Our Ref: - D02469961 - F2010/ 00286
Contact Officer: Elias Coorey - 9399 0524

Subject: Notification section 75W modification request to Project Approval at Royal Randwick Racecourse (MP 10_0098 MOD 1)

Council would like to provide the following comments/conditions for consideration of the proposed Section 75W Modification Request to Stables Project Approval MP 10_0098:

Figure 3: Proposed construction staging plan

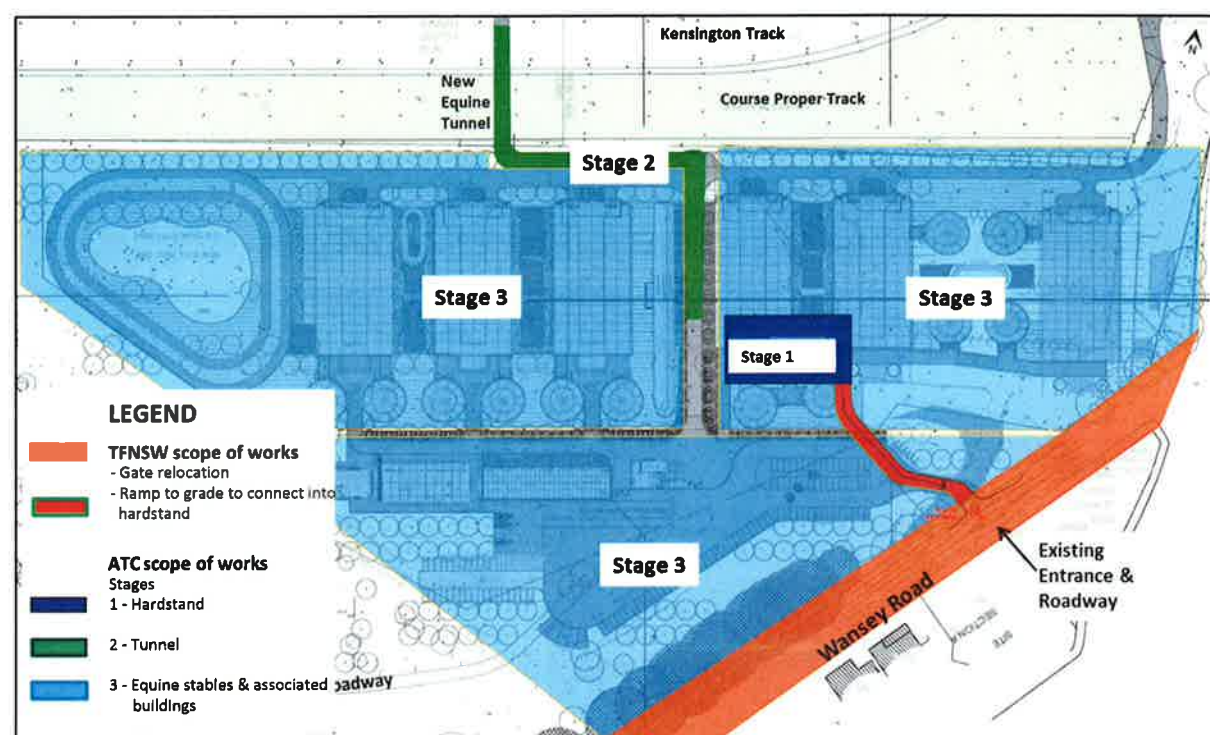
This Plan primarily details the proposed 3 stages of construction work for which approval is sought under the Section 75W modification request. Specifically, **Stage 3 – Equine Stables and Associated Buildings** is divided into three areas with each area designated a distinct colour. This colour coding suggests a further sub-staging within Stage 3 which is not explained in the request and, therefore, is unclear, resulting in consequences for the function/effectiveness of a number of conditions that are proposed to be reworded as part of the subject modification. In particular the repeated use of the words "prior to ... Stage 2 or subsequent stages of the proposed development" in a number of modified conditions in **Appendix D – Schedule of Amended Conditions** lacks clarity having regard to these colour coded areas of Stage 3 (as detailed further in the assessment below).

The subject modification also includes a designated area coloured orange with the caption:

TFNSW scope of works

- Gate relocation
- Ramp to grade to connect into hardstand

Apart from the driveway, these TFNSW works are located outside the Stables boundary with no designated time-frame as to how it fits into the overall staging plan. Clarity should be further provided as to the nature and timing of the TFNSW scope of works as these relate to the overall Stables staging plan. It appears that the driveway is intended to be constructed prior to Stage 1 works. No objections are raised to this arrangement provided the proposed Stage 1 Construction Zone is confined to its designated blue zone. Additionally, Wansey Road is shown with details of the currently approved road reserve containing traffic and parking lanes and shared cycle-ways. It would be more appropriate to show the CSELR configurations for Wansey Road and how these match the proposed driveway works. It is noted that, at the time of writing this letter, Transport for NSW (TfNSW) has still not finalised the proposed layout of the Light Rail alignment. It is also noted that, as the proposed Light Rail alignment will likely shift the driveway westerly, there will be a need to either increase the gradient of the proposed ramp/road or a need to shift the ramp/road westerly. It is imperative that the gradient of the ramp on approach to the pathway system in Wansey Road meet the requirements of the relevant Australian Standard, to ensure that drivers' view of all categories of pedestrians is maintained.
